**Consultation Response from KC,
Lead Local Flood Authority**

2020/93954 Land at, Lingards Road, Slaithwaite, Huddersfield, HD7 5HY

Erection of 42 dwellings and associated works

Date Responded: 22nd June 2022

| SITE PLAN 2                                                                                                           |          |            |  |

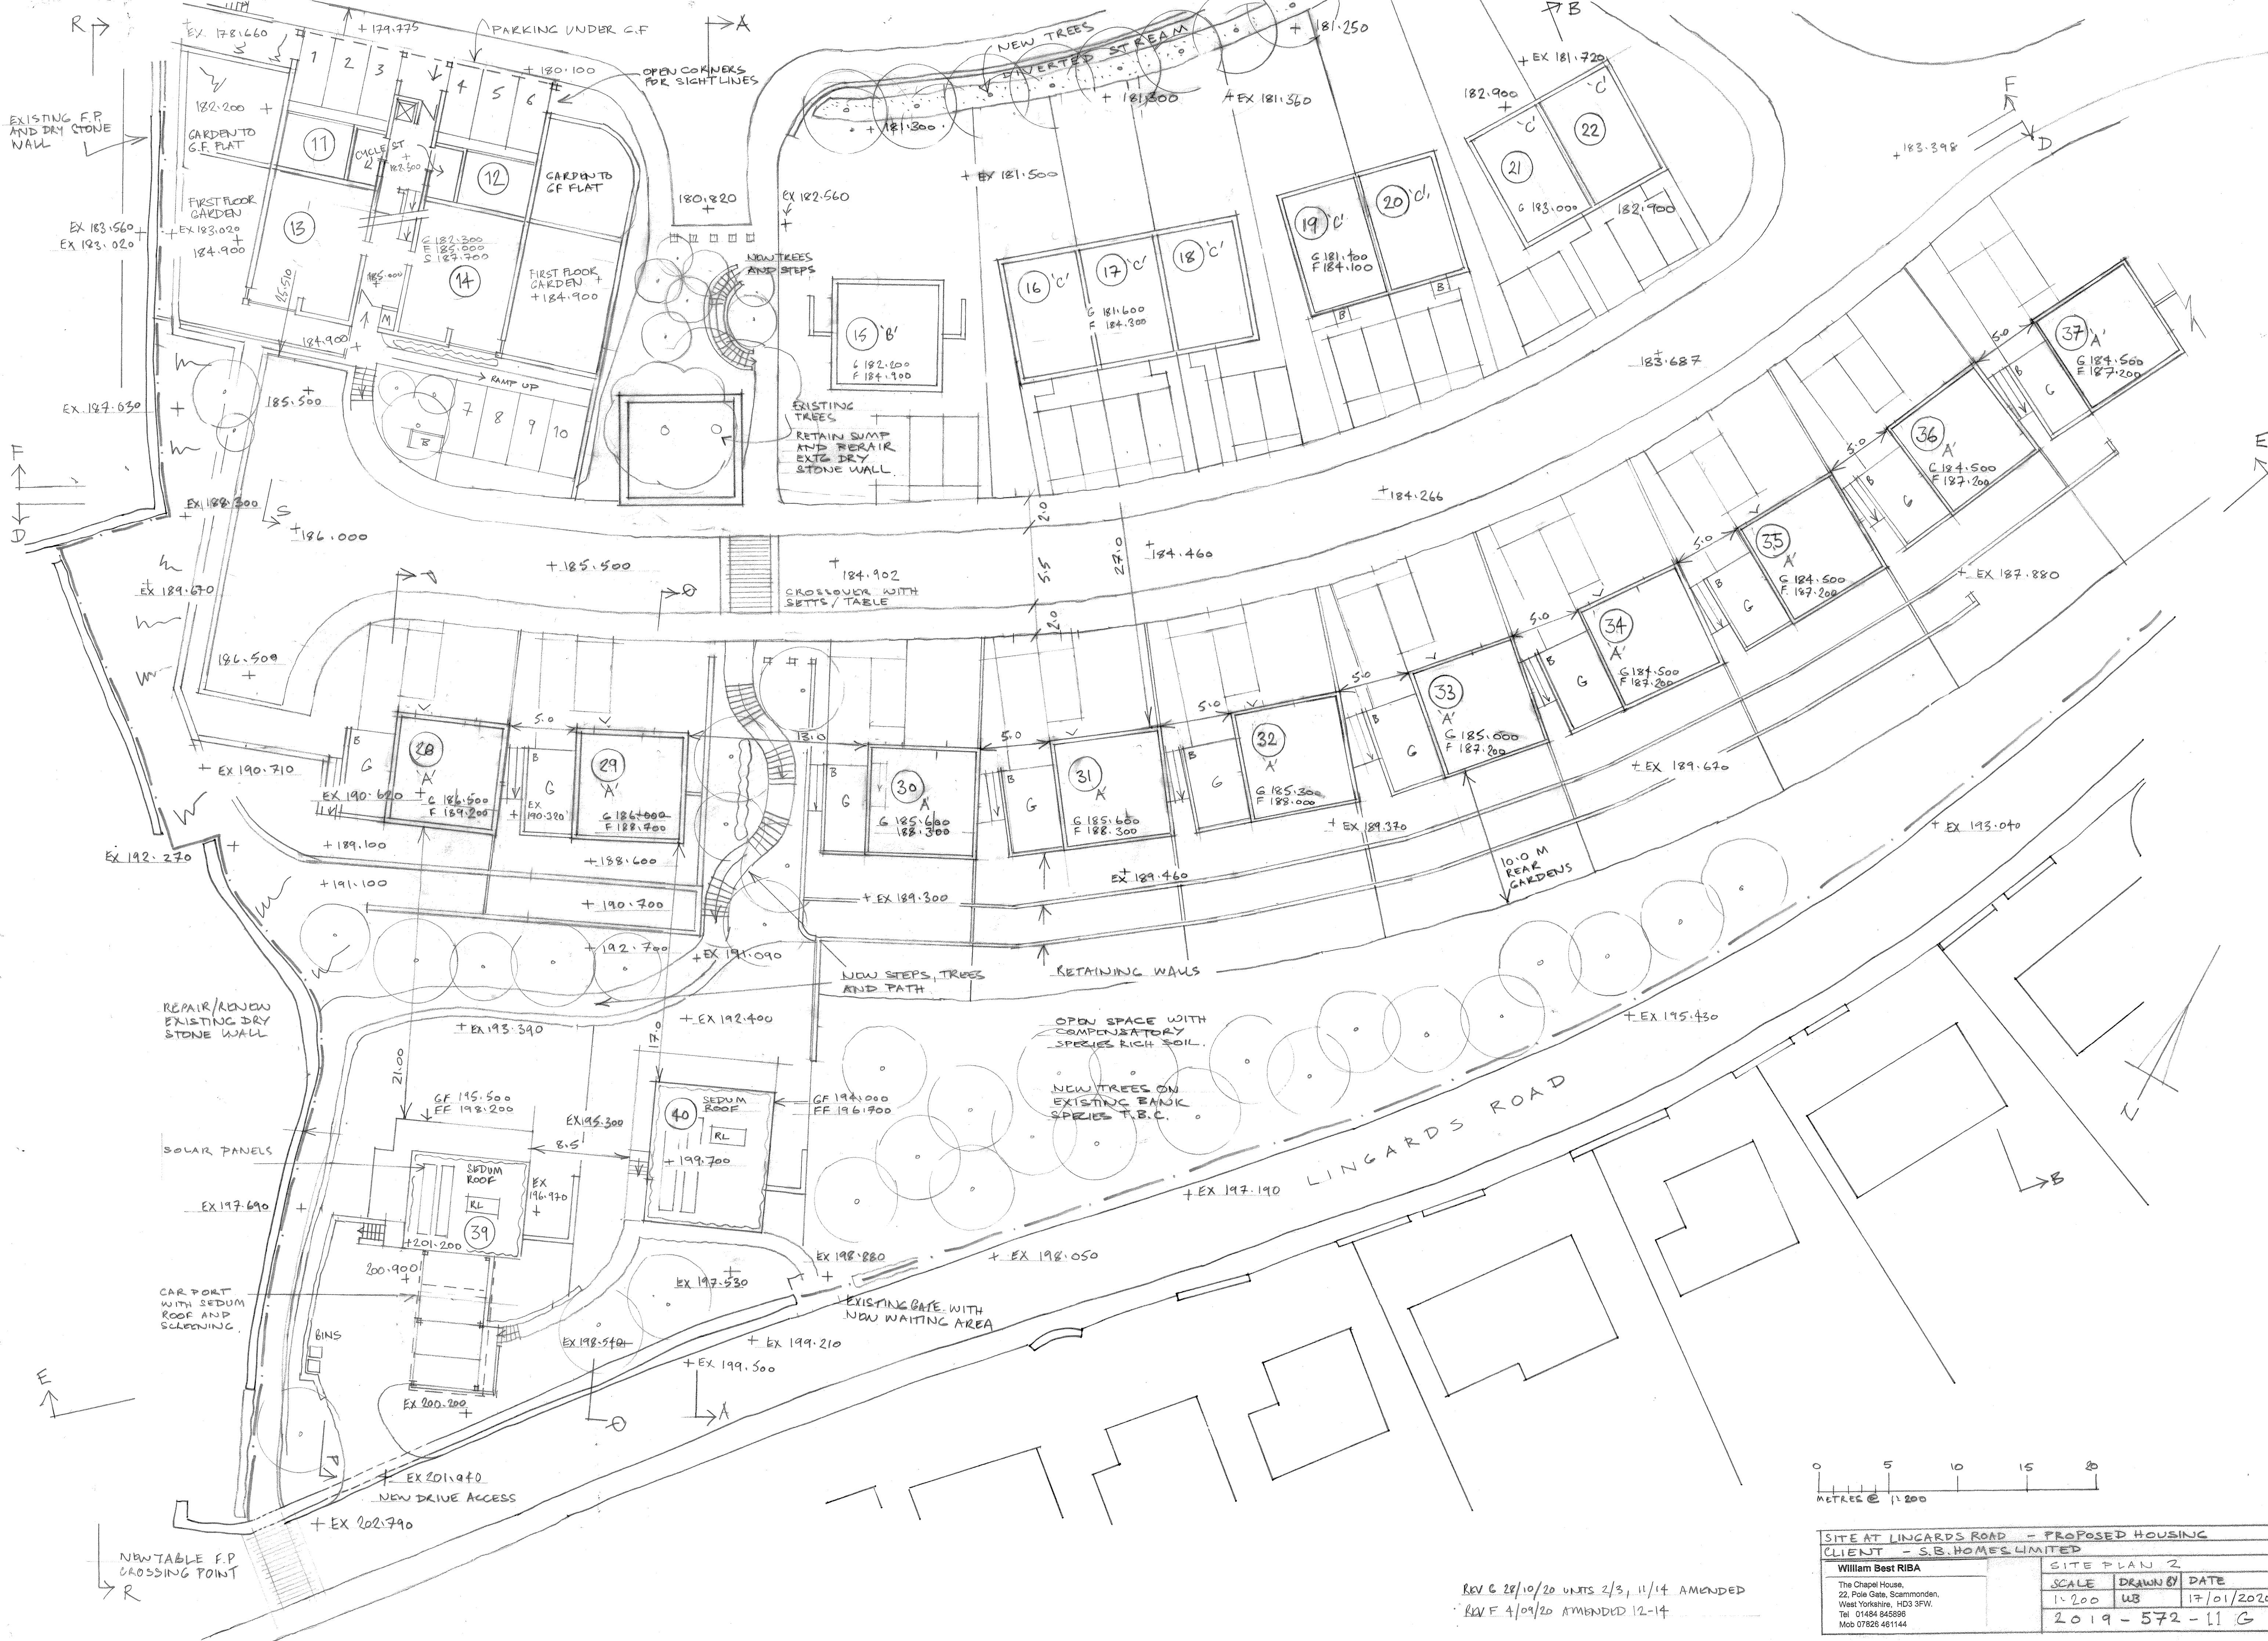
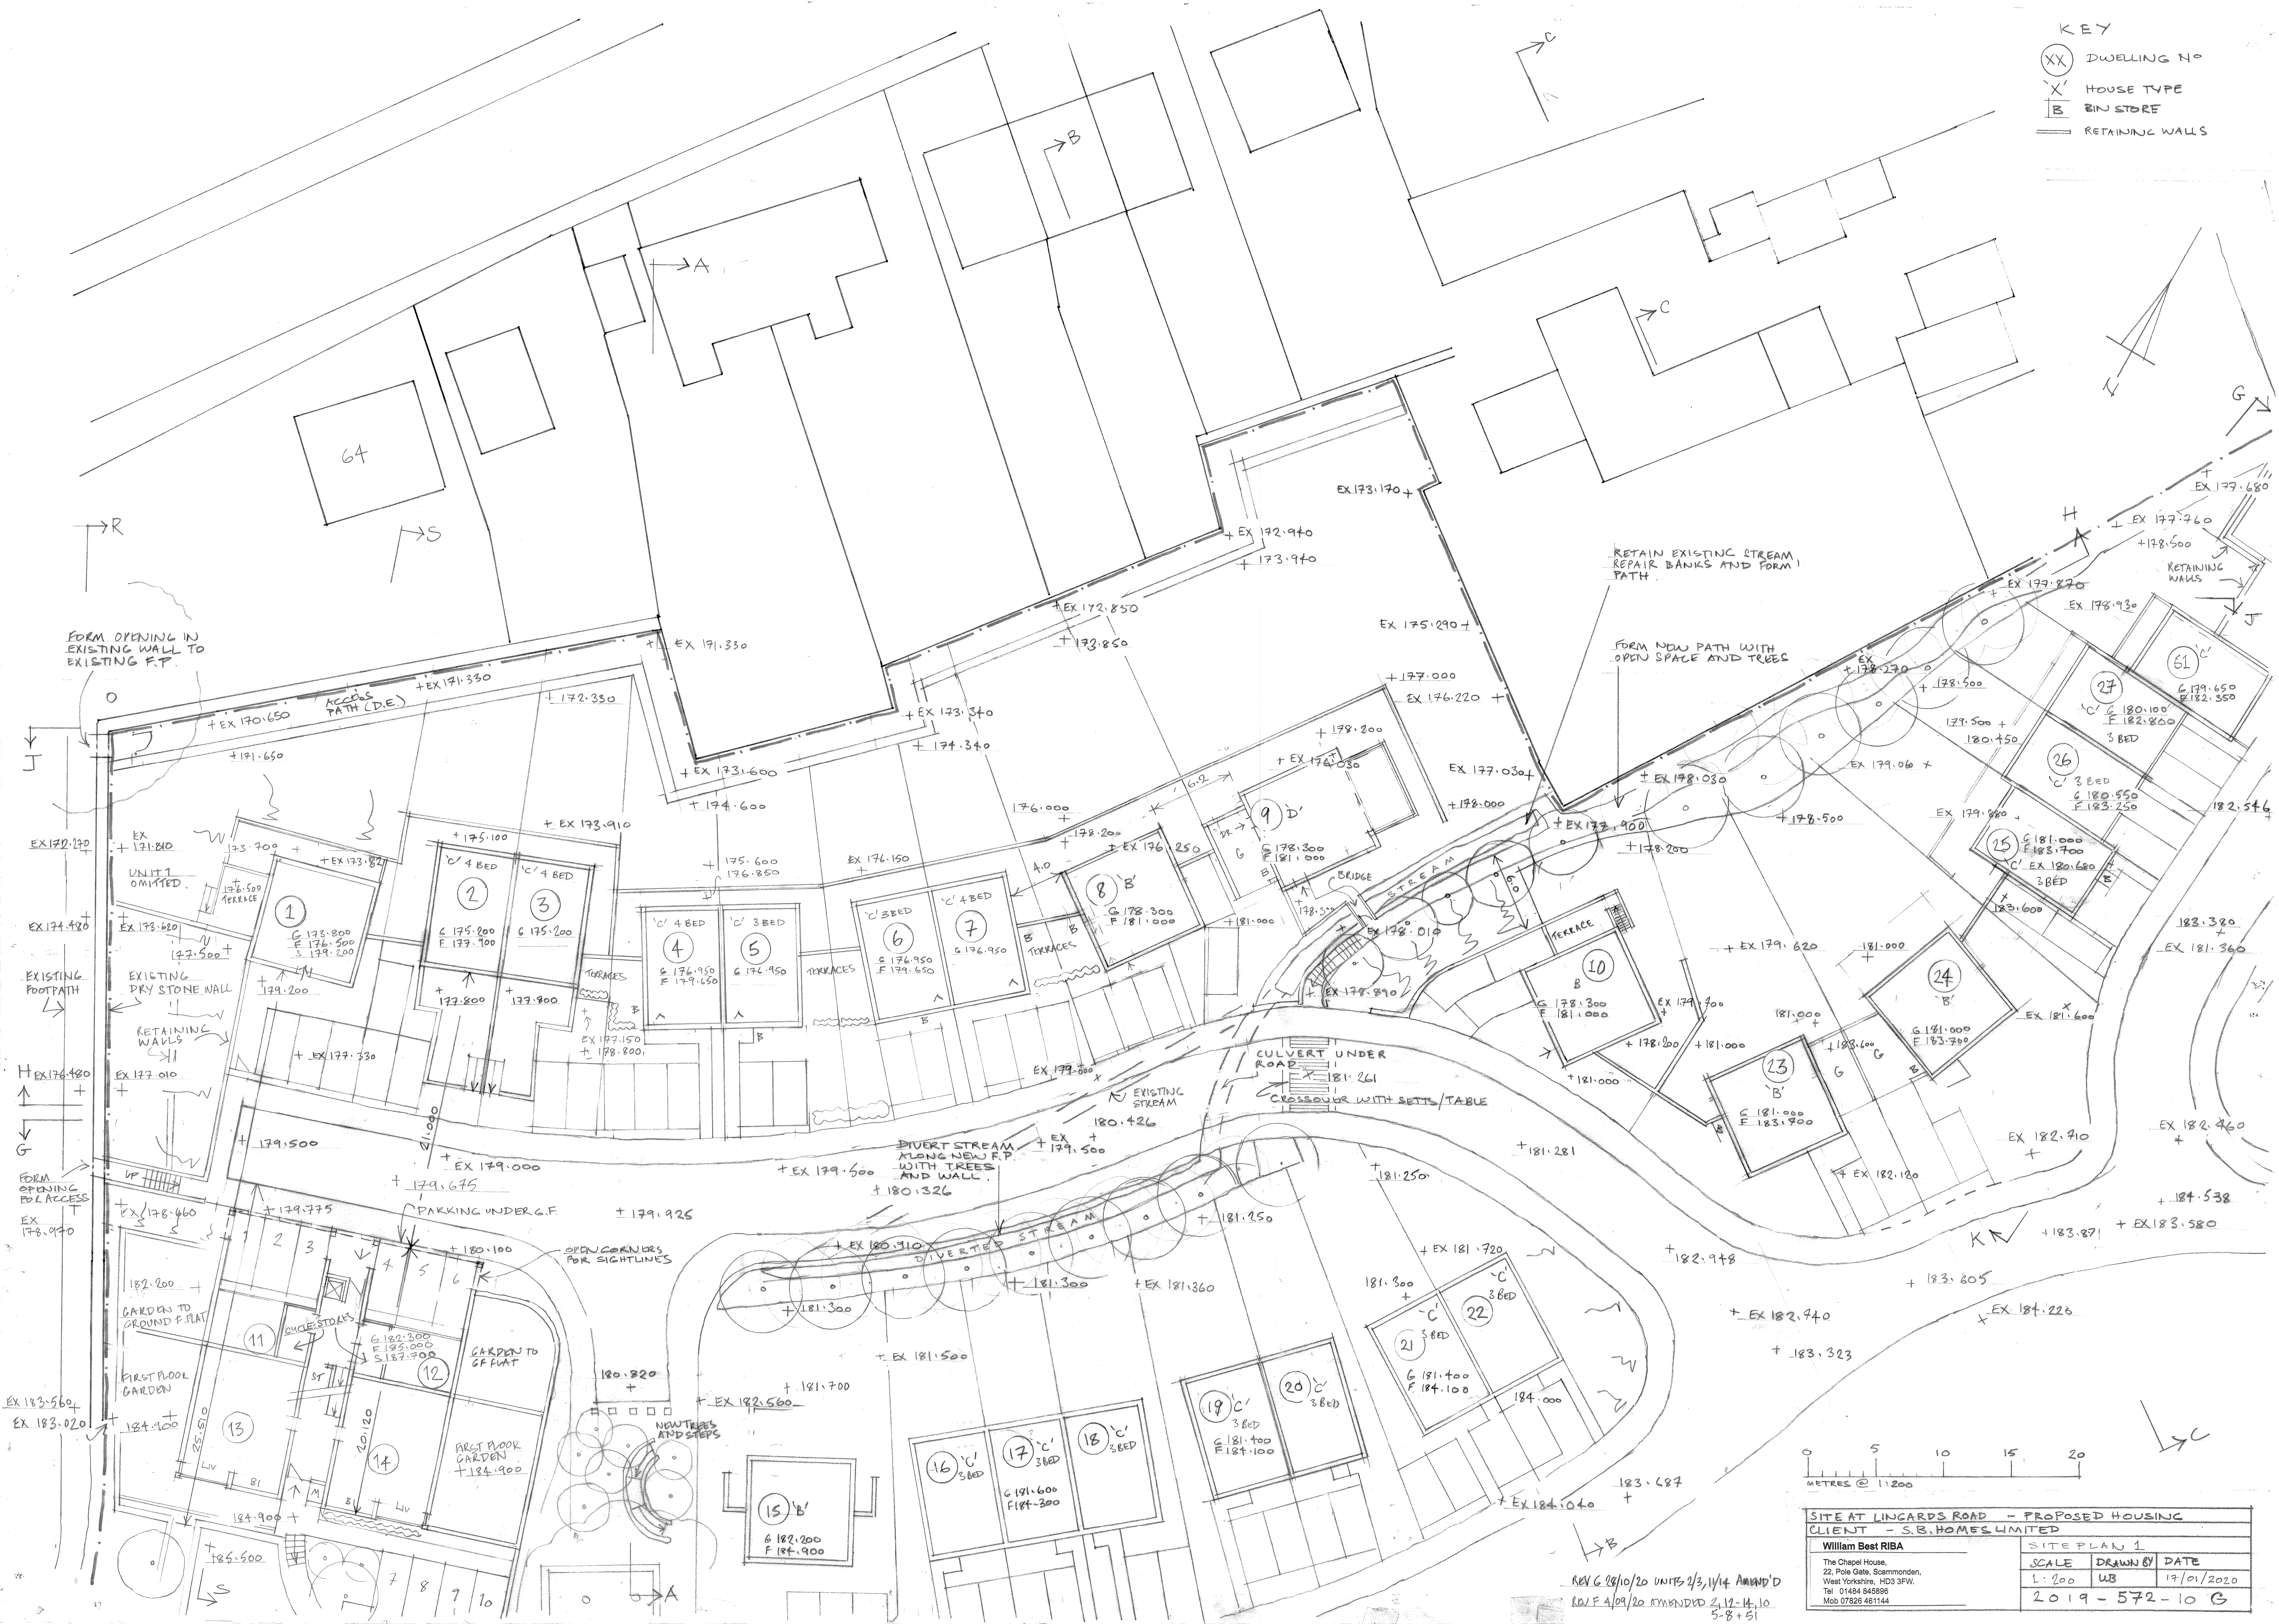
Whilst it is recognised that some on site research has taken place and an attempt to incorporate findings into the layout design, this is not comprehensive and no narrative of justification of the layout has been promoted.

An assessment of existing overland flow routes, and blockage and exceedance events with regard to current land drainage design, including pump house, valves and overflows and how layout will alter this and avoid surface water flood risk to properties has not taken place.

To overcome this objection, the flood risk assessment must fully understand current site drainage and clearly demonstrate how the site design fits in and adequately manages these constraints and the flood risk associated with them. We recommend to the planning officer that an on-site meeting takes place and the application liaises with adjacent and downstream riparian owners of watercourses that flow through the site. The development is therefore unsafe in its current format and the number of properties in any resubmission may need to be altered.
